Item No. **Report of the Head of Planning, Transportation and Regeneration**

Address 29 PARKFIELD ROAD ICKENHAM

Development: Erection of a replacement dwellinghouse with associated car parking and landscaping, following demolition of the existing bungalow

LBH Ref Nos: **14459/APP/2021/1343**

SITE PLAN
1:500

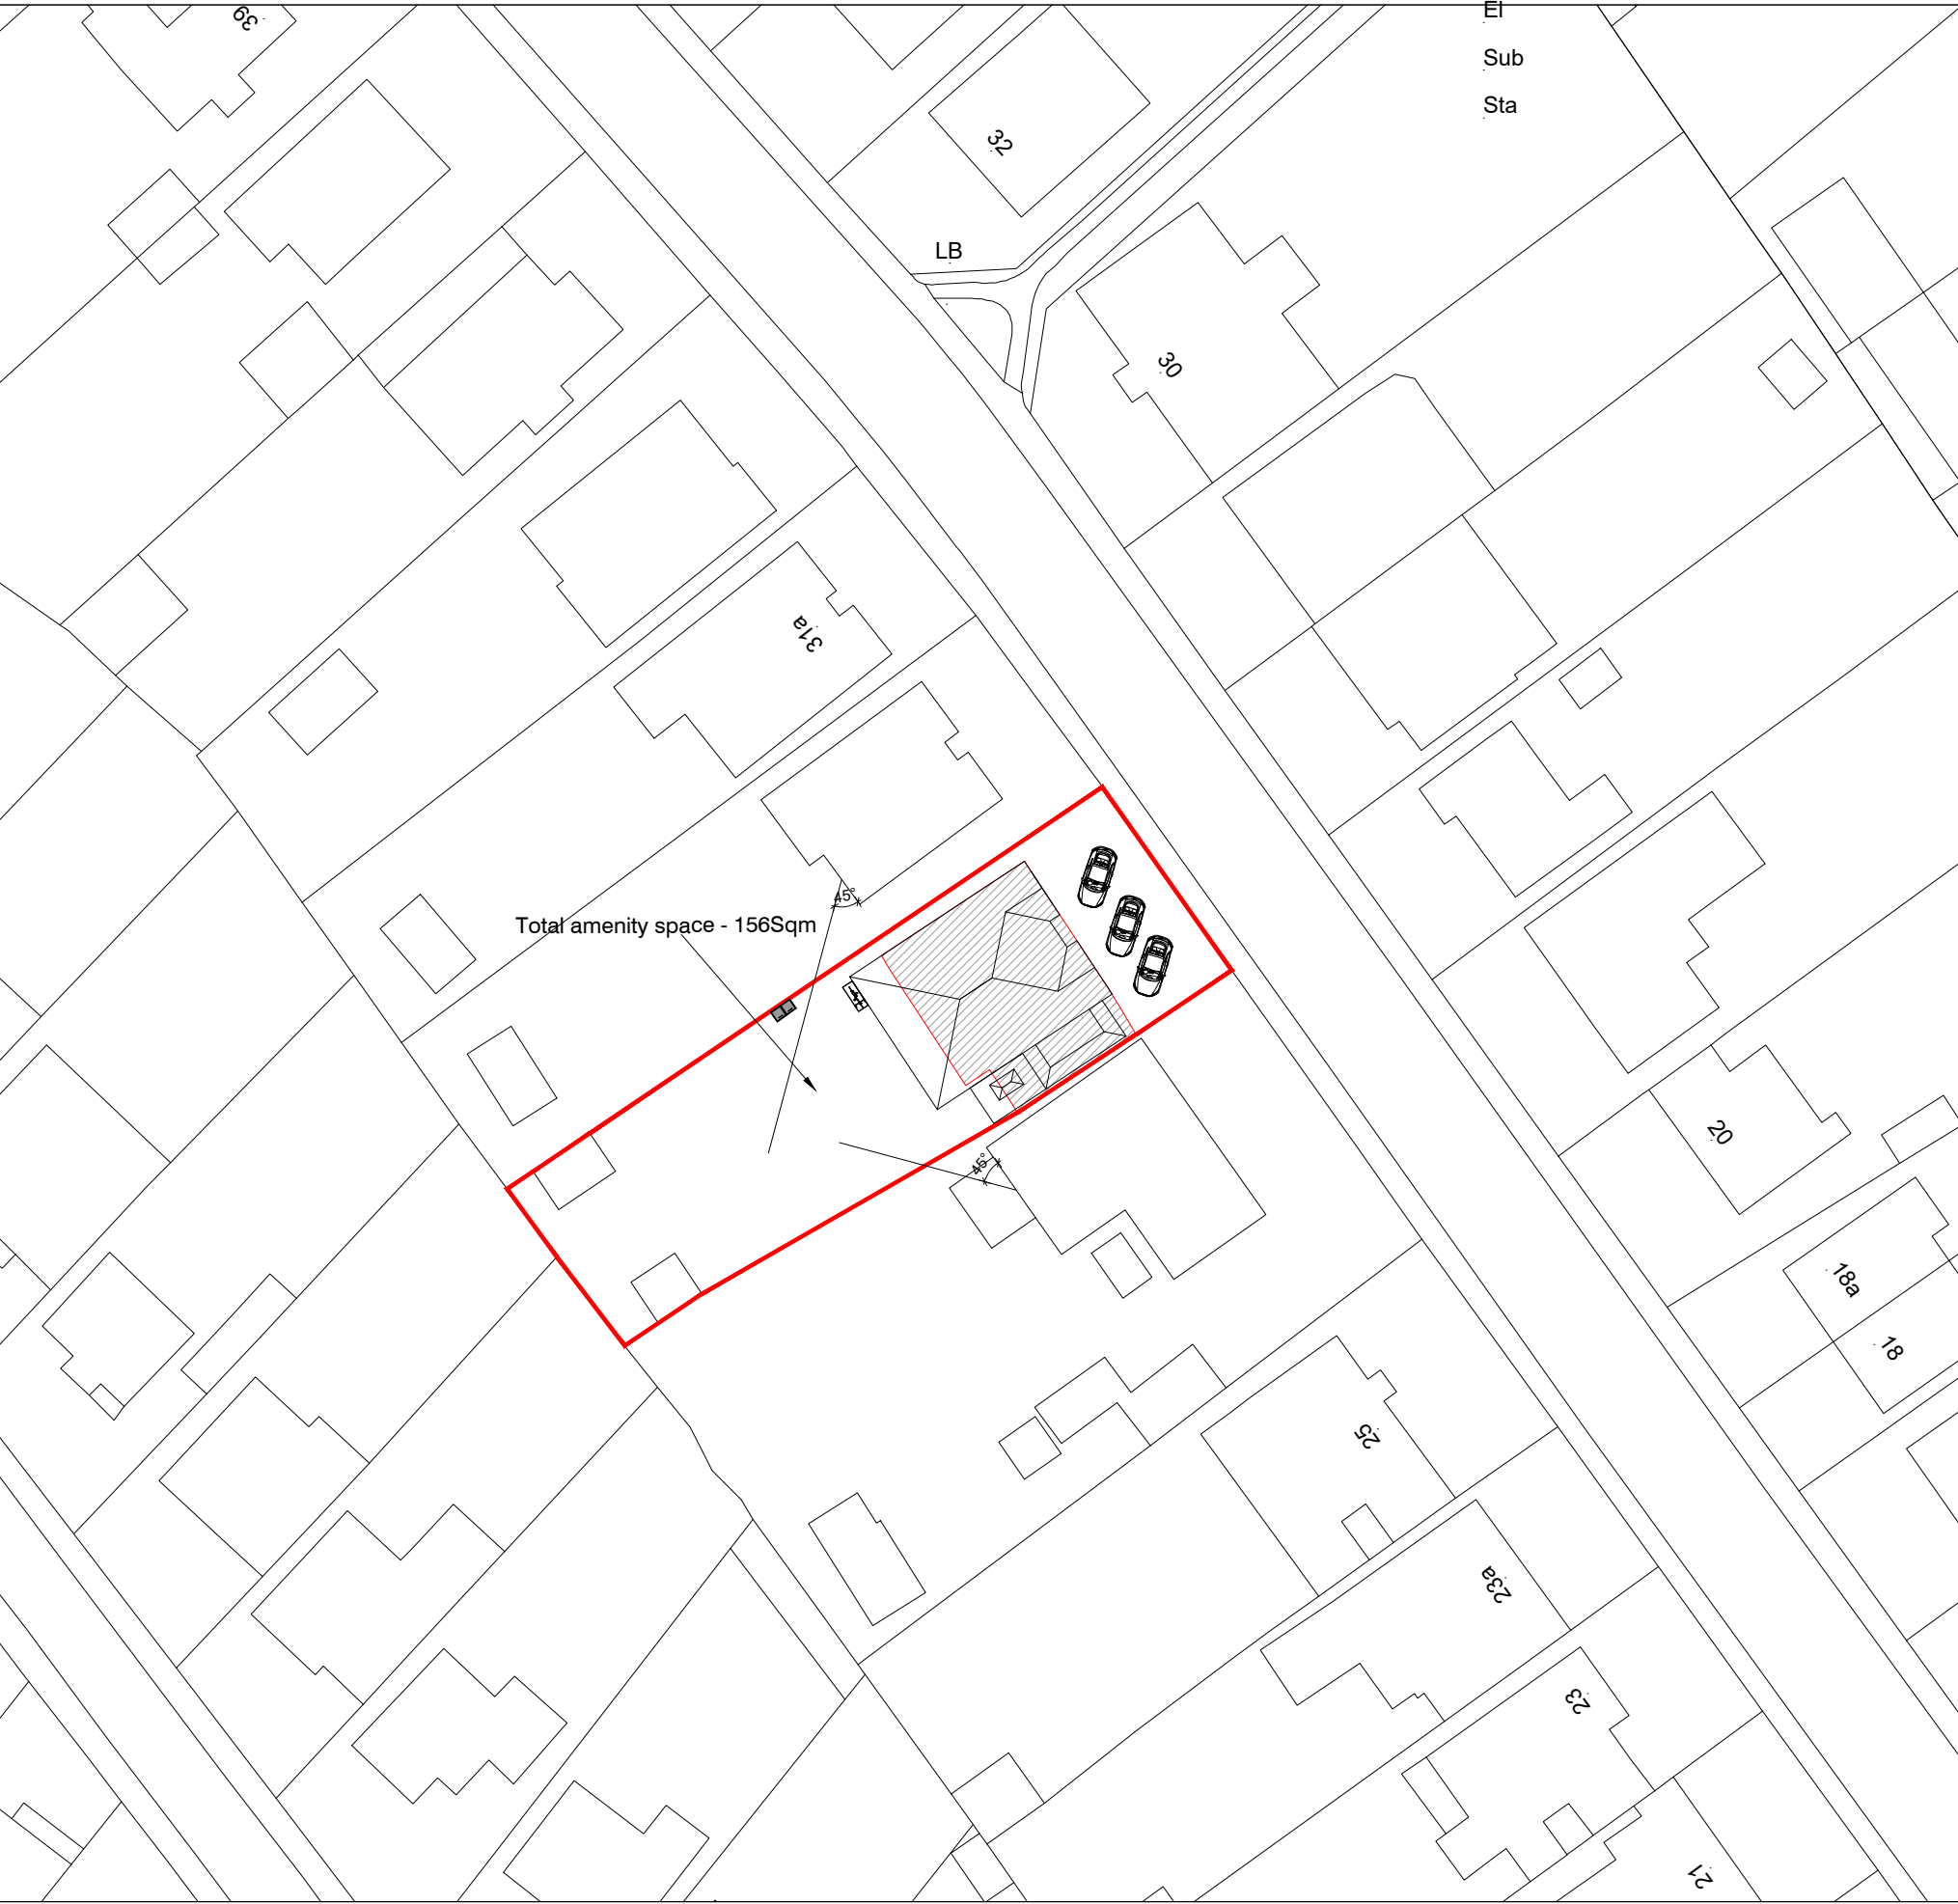
COMMENT: No trees will be affected by the proposed footprint of the building, however, the expansion of the driveway will lead to the removal of established vegetation which is indicated to be replaced by very small meaningless planting pockets. Ideally the existing planting should be protected retained or, at least, replaced with reasonable areas of soft landscape along the front boundary.

The local plan maximum car parking standard requires up to 2 spaces to be provided on-site. It is noted that the site plan makes reference to car parking for three cars. Notwithstanding the proposed plans, should the application be considered acceptable, a landscaping condition is required to provide details of soft landscaping and front boundary treatment to ensure the property continues to contribute to the streetscene and provides only up to 2 car parking spaces in line with Policy DMT 6 of the Local Plan: Part Two (2020).

indicated to be replaced by areas of planting. The revised plans illustrate more generous planting within the front garden which is considered appropriate. Should the application be considered acceptable, details of tree protection and hard and soft landscaping would be required by condition.

PROPOSED FRONT ELEVATION
1:100

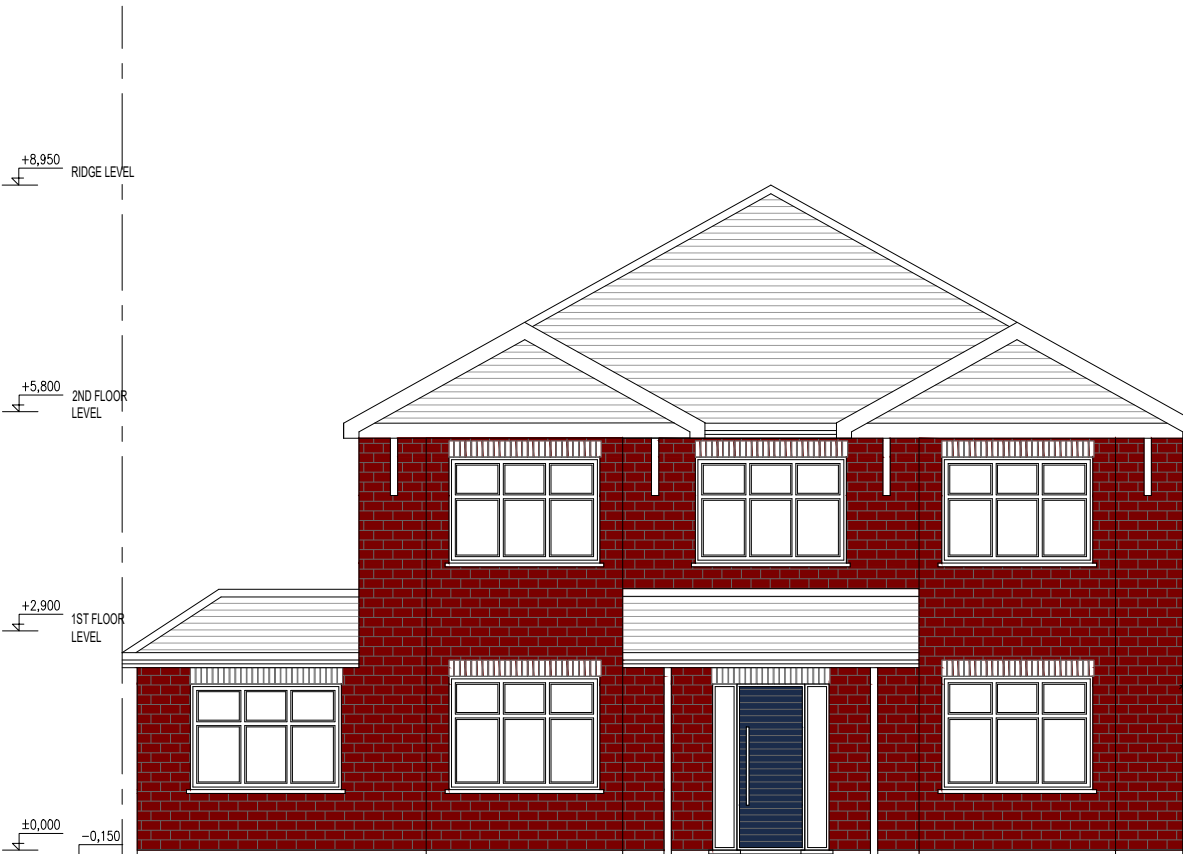
The proposal seeks to provide a 2-storey building with double fronted bays. Whilst the front building line is consistent with the adjoining properties, its scale, width and depth is larger. As a result of the applicant's attempts to reduce the height of the building, the latest amended plan submitted by the agent on 21-05-2021 includes a crown roof which exacerbates the bulkiness of the building. The materials include red brick, roof tiles and white UPVC framed windows on the front elevation.

Whilst the wider streetscene of Parkfield Road is characterised by a variety of architectural styles, this part of Parkfield Road comprises a distinct pattern of development and within this context, the replacement dwellinghouse due to its size, scale and design fails to transition appropriately between the bungalow at No. 27 and the property at No. 31. The proposed development has failed to have regard to the local context and fails to harmonise with the local context.

amended plans made alterations to the height of the dwellinghouse, however the alterations do not overcome the objections set out above. The pre-application advice was taken into account in coming to a decision, however following a detailed review of the proposal, a review of the plan illustrating the proposal within the streetscene and the neighbouring objections, the proposal is considered inappropriate.
